RMS Ref: SYD15/01473/02 (A13289080)

Council Ref: SSD 7382

EXHIBITION OF EIS – UTS BROADWAY PRECINCT
15 BROADWAY, ULTIMO

Phase 1

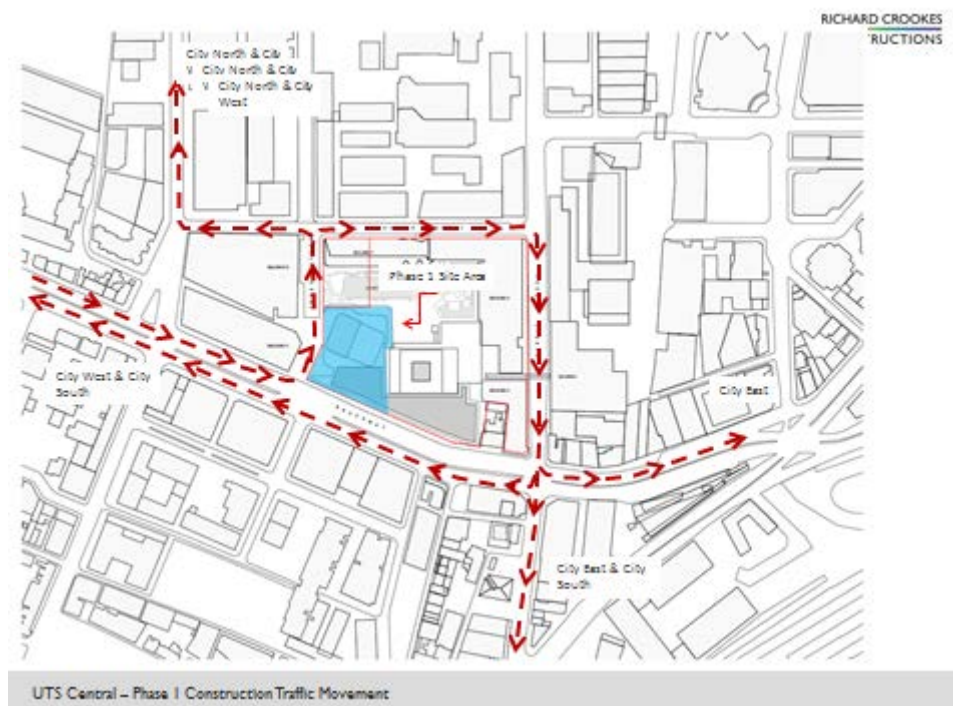
1. Roads and Maritime raises no objection to the temporary access to Jones Street provided traffic controllers are present at all times during construction hours to ensure the access is used by constructions vehicles only and pedestrians are protected. The integrity of the footpath must be maintained and pedestrians are to have right of way.

Phase 2

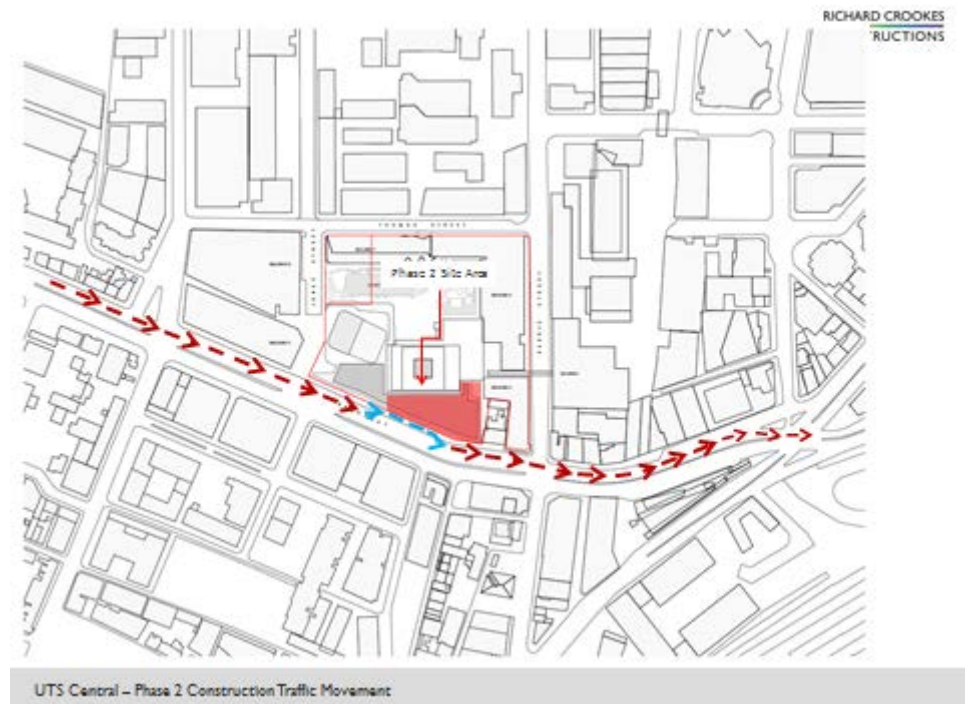
2. The applicant is to consult with Roads and Maritime, together with other stakeholders prior to the commencement of Phase 2 works to seek approval for construction vehicle access to the frontage of the Building 1.
